PLANNING AMENDMENT²⁰⁰

Application No. H16/0804/02/A1
Date Registered 18 SEP 2002
Case Officer PTM

ALTERATIONS & EXTENSION
TO BUILDING

Amendment: Removal of two high level windows in north west elevation
Dwg.No. 3090-001A

Proposed Elevations.

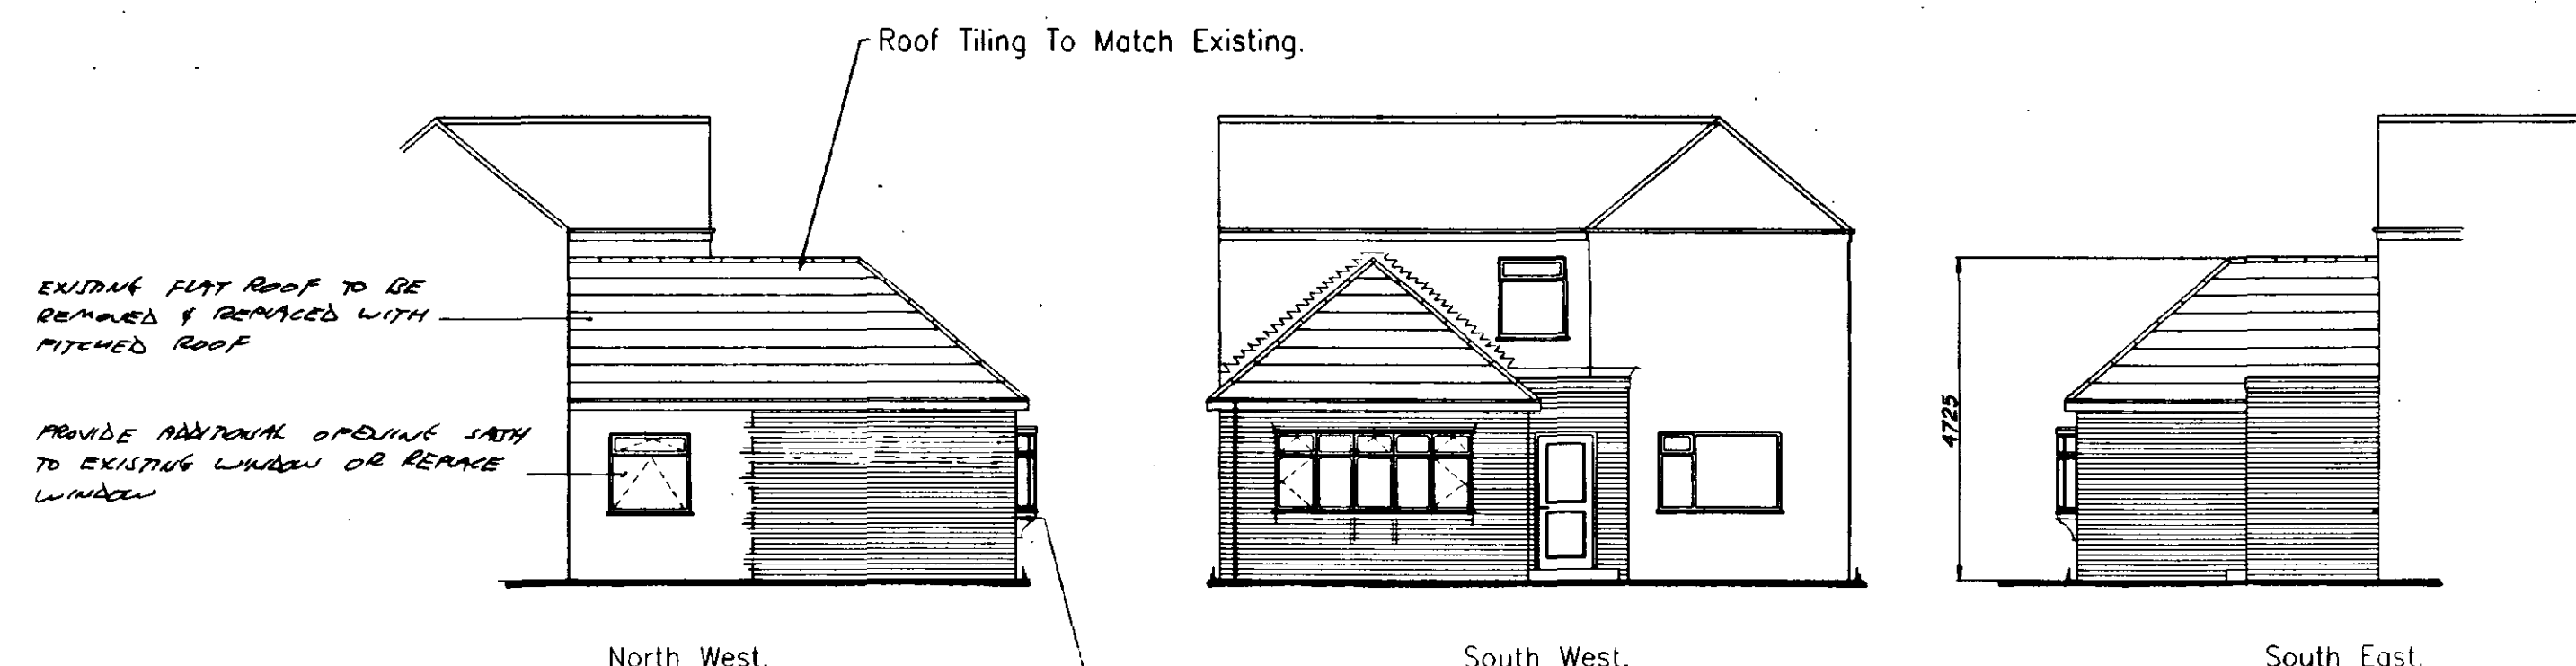
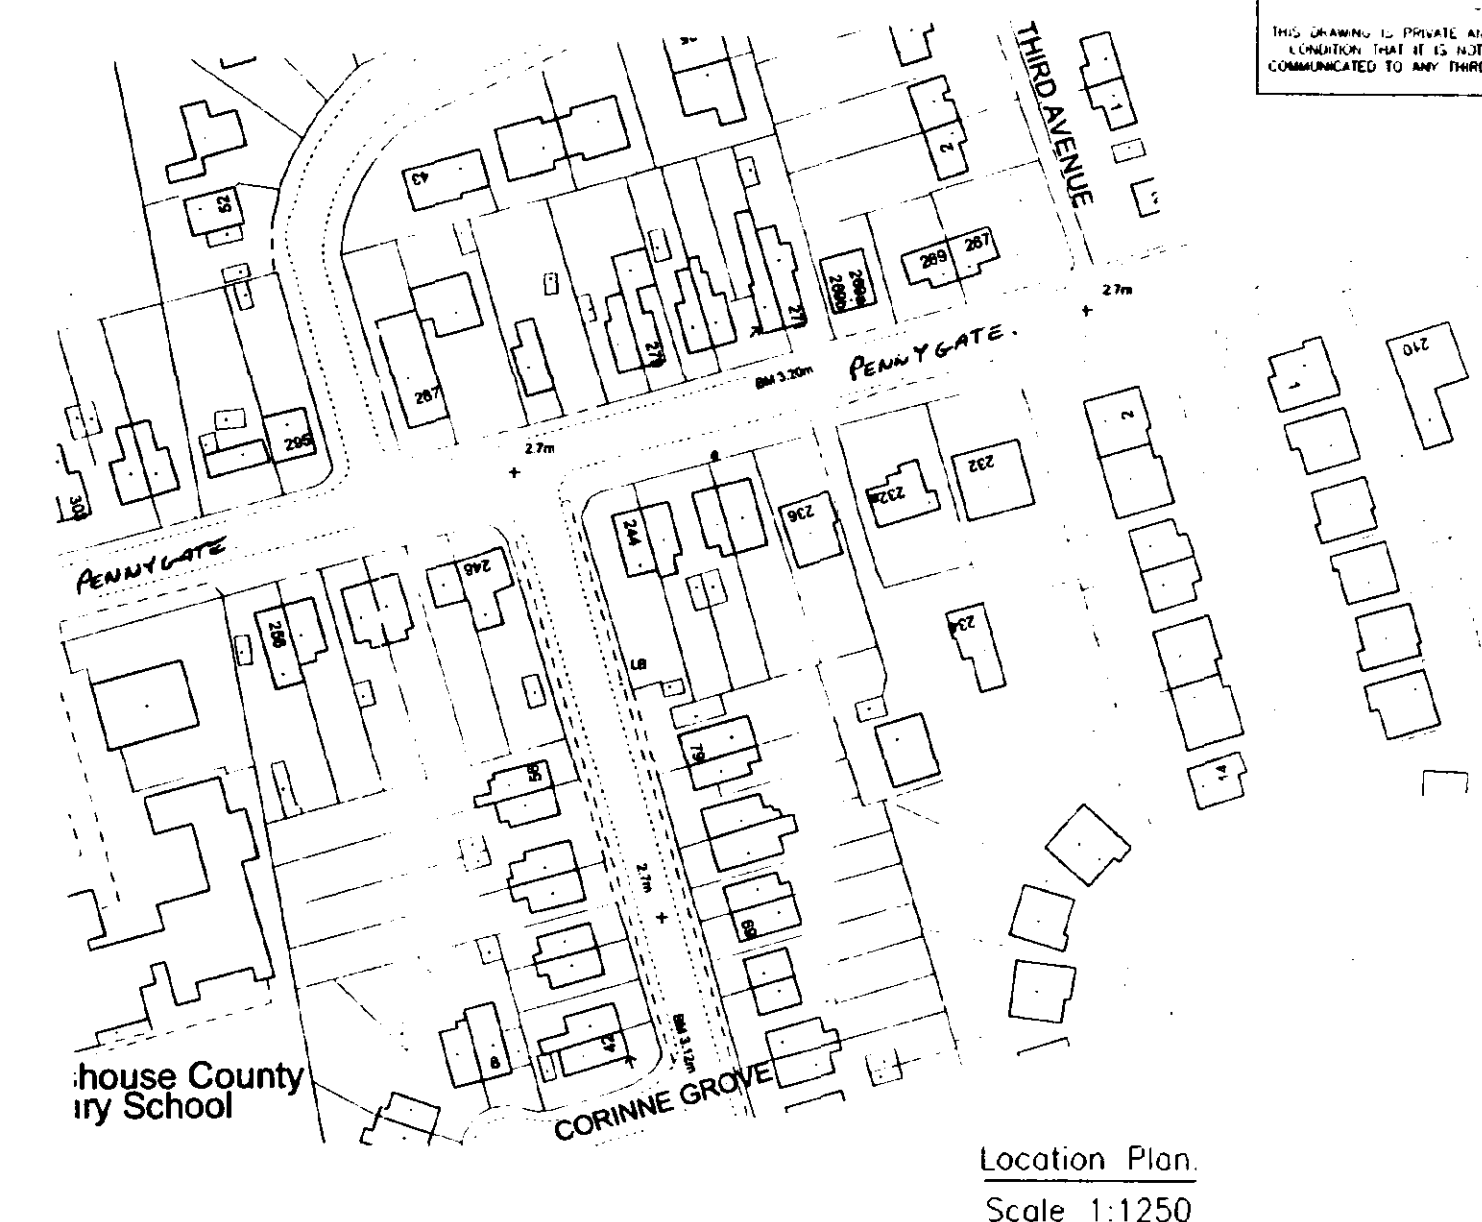
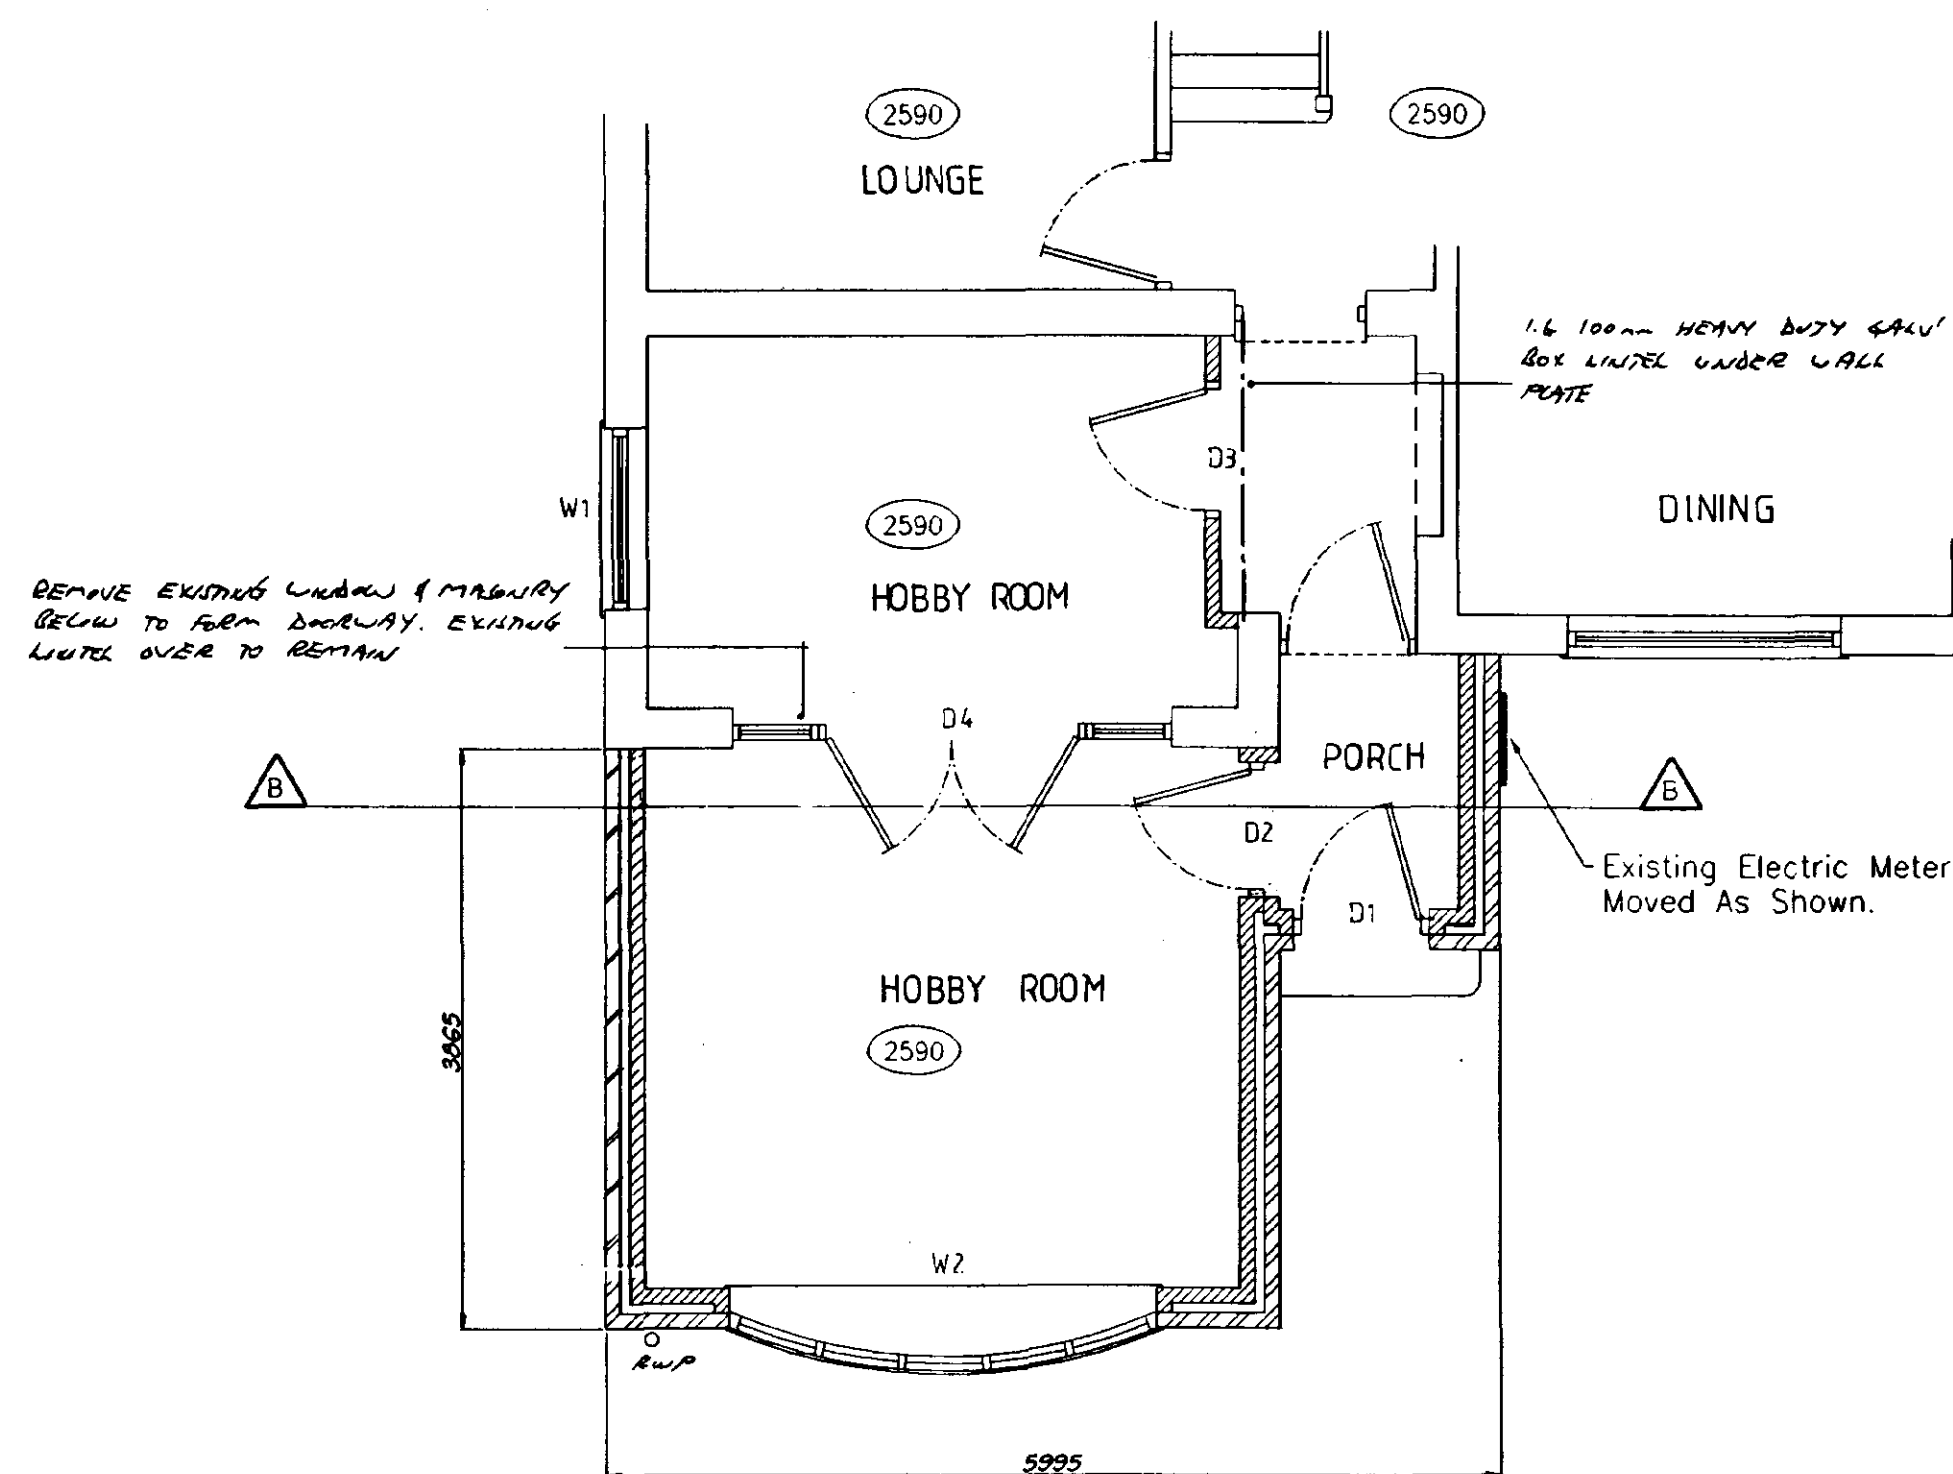
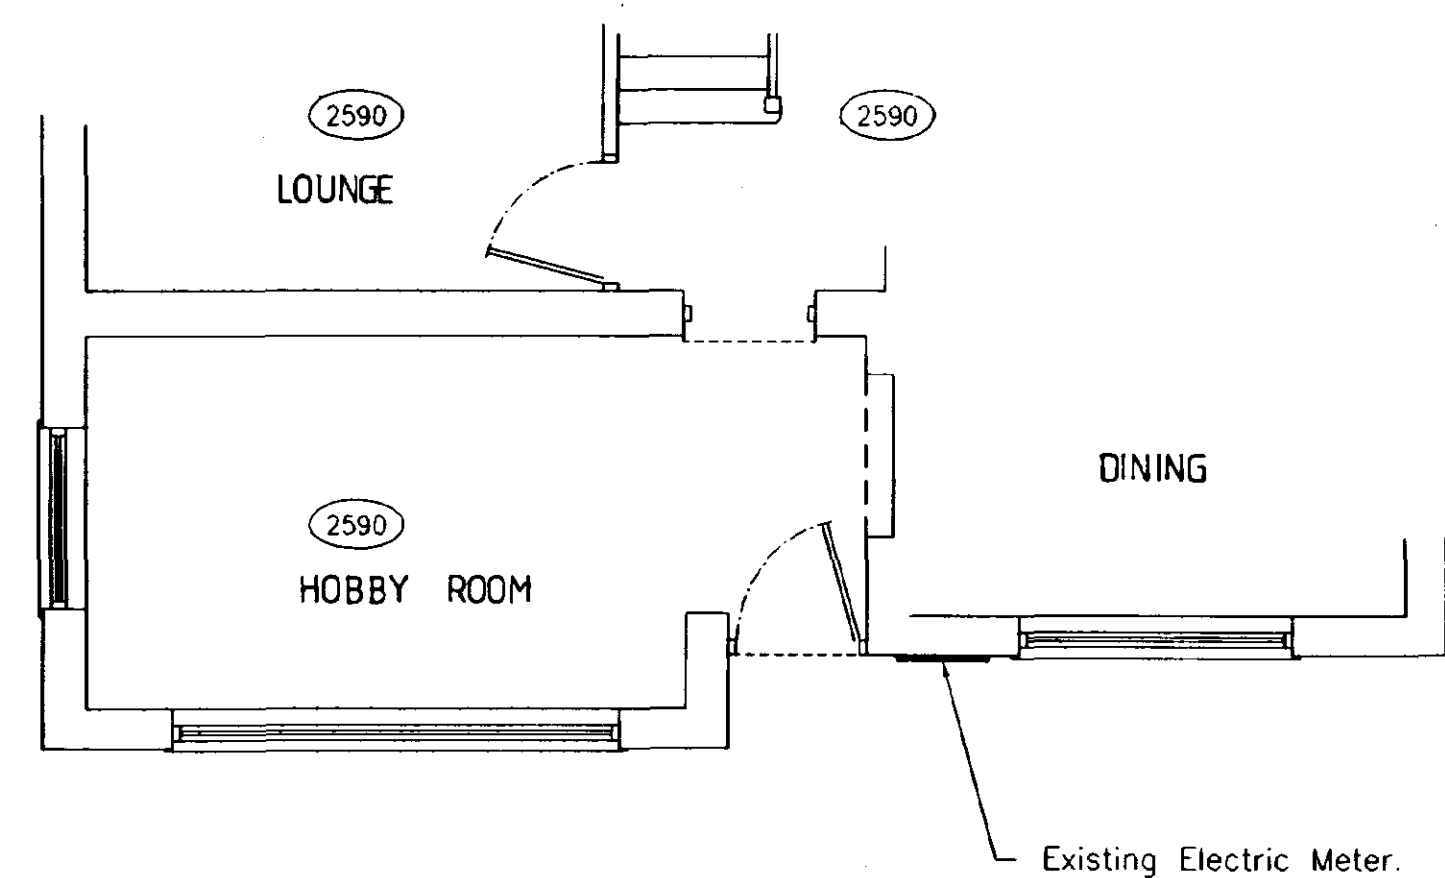
REMOVE 2 NO HIGH LEAD
WINDOWS IN NORTH WEST
ELEVATION

The amended details submitted in respect of the above proposal have now been considered and there are no objections to the amendment being implemented to the extent described above.
